Subject: P/70/19/RES Summer Lane

I would like to respond to some of the points made by the Parish Council in your recent consultation response dated 11th December 2019.

The applicant has highlighted to me that they initially showed an access from the Public Open Space (POS) to the adjacent Village Hall land (on their first plan ref M323-350 Rev P4 – attached for your reference) and that that in the Parish's first response (13/09/19), it was stated that: *"Access arrangements will need to be reviewed as the submitted plans assume access is possible through the paddock field currently in the ownership of the Parish Council. The field is next to a car park, but this services the Pagham Village Hall and is not open unless the hall is in use. The Parish Council does not control the carpark or hall."*

Drawing Number: M323-350	Revision: P4
--------------------------	--------------

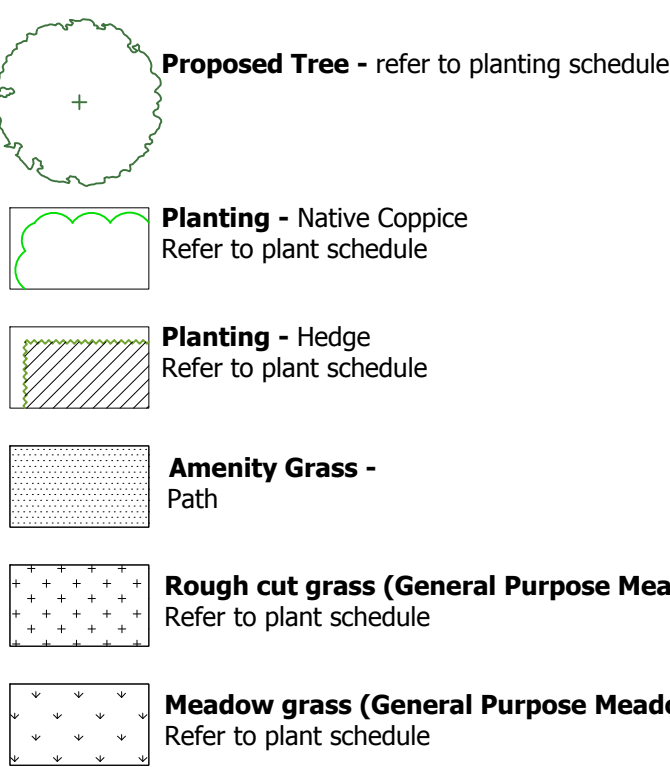
It was for this reason, that the applicant removed the proposed access between the POS and the Village Hall land. However, they have stated that they would agree to a planning condition that seeks to secure an access point if the Parish are now requesting this.
